RE: 8300 Calle Nortena NW
Grading Plan
Stamp Date: 4/3/17
Hydrology File: C11D003

RE: 8300 Calle Nortena NW
Grading Plan
Stamp Date: 2/7/17
Hydrology File: C11D003

ENGINEER'S SEAL DAVID SOULE NEW MEXICO REGISTERED PROFESSIONAL ENGINEER 14522 4/3/17	8300 CALLE NORTENA FECTEAU RESIDENCE GRADING AND DRAINAGE PLAN  <i>Rio Grande Engineering</i> 1606 CENTRAL AVENUE SE SUITE 201 ALBUQUERQUE, NM 87106 (505) 872-0999	DRAWN BY WCWJ DATE 3-06-17 21715-LAYOUT-3-06-17
		SHEET # — JOB # 21715

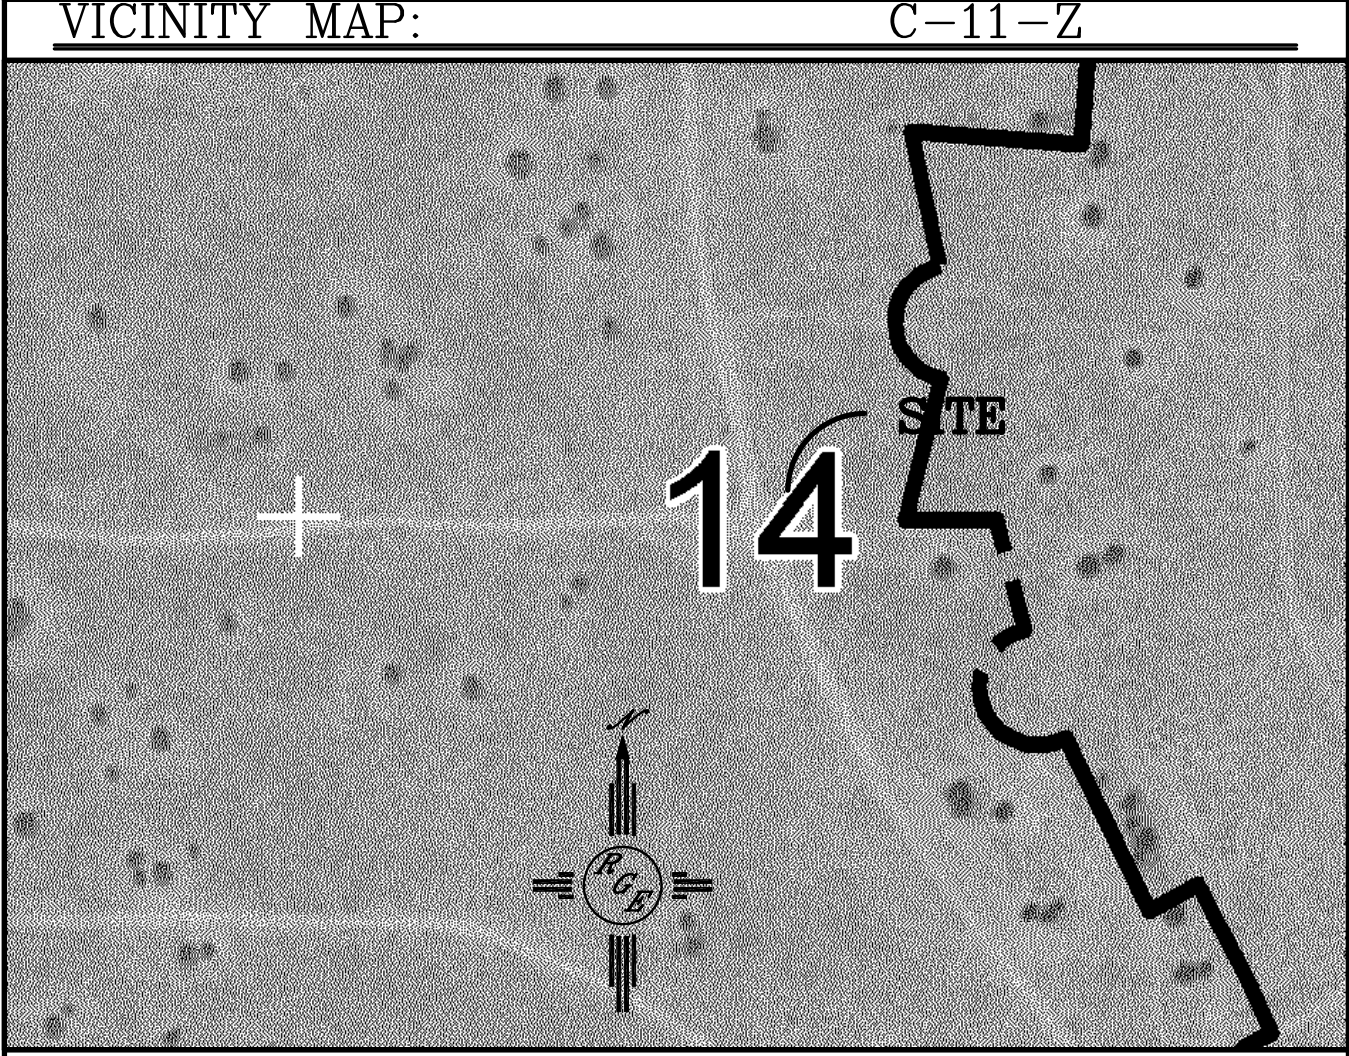
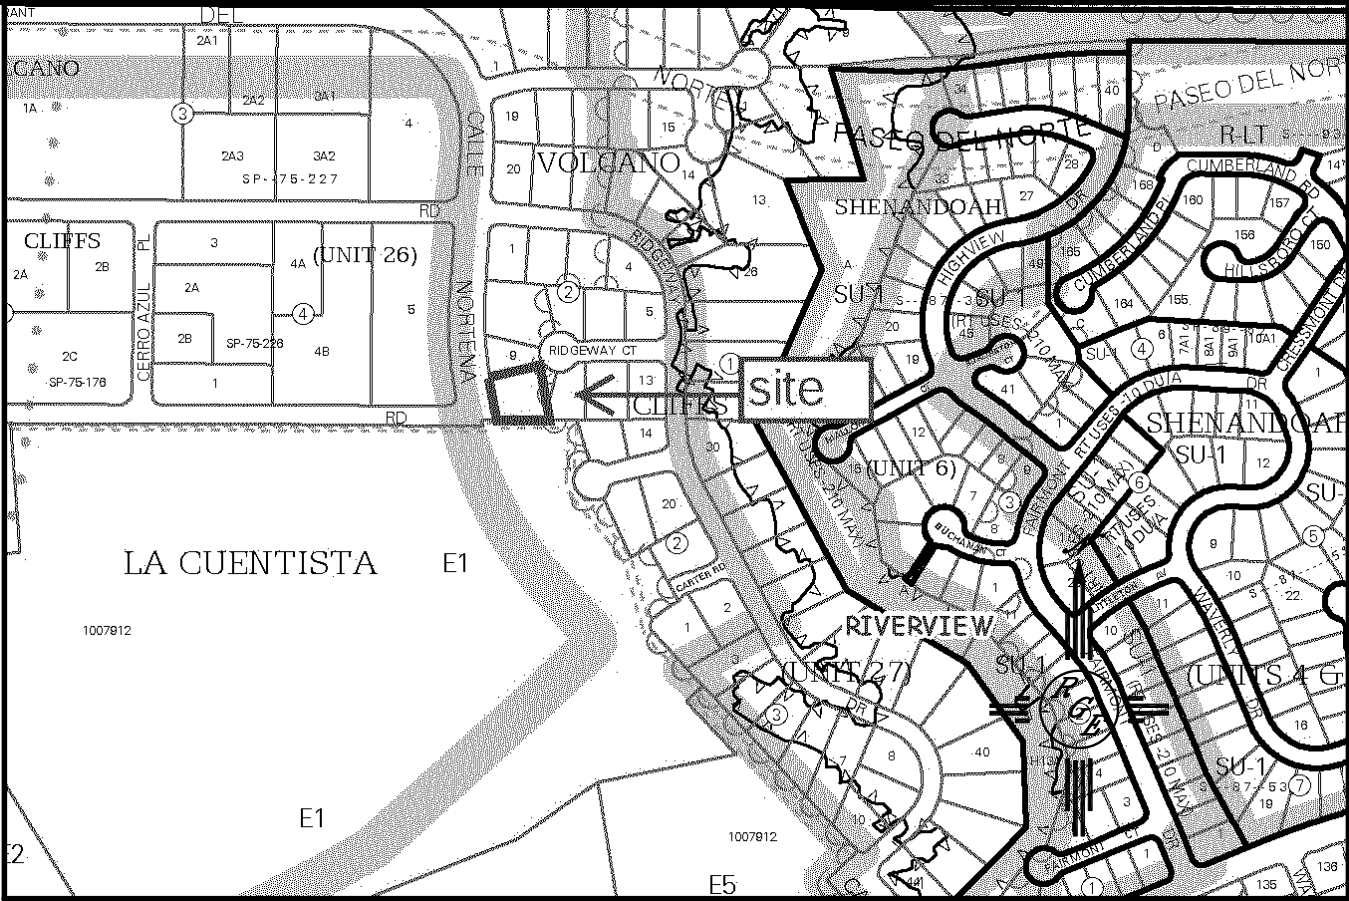
Based upon the information provided in your submittal received 3/7/2017, the Grading Plan **is not** approved for Building Permit. The following comments need to be addressed for approval of the above referenced project:

1. It appears that you calculated required volume for capturing the first ½ inch (detention) is low. It should be 0.02 ac-ft or 871 CF.
WE HAVE INCREASED BUT I CALCULATE $15199 \times (.5) / 12 = 633$
2. The proposed grading appears to actually separate the site into two separate drainage basins. The north half drains to the proposed pond. The south half drains to the southeast corner of the site. The south half of the site's drainage is not captured by a pond and just directly flows off site. You need to create a pond to capture the runoff.
WE HAVE MODIFIED THE POND TO CAPTURE ALL BASIN
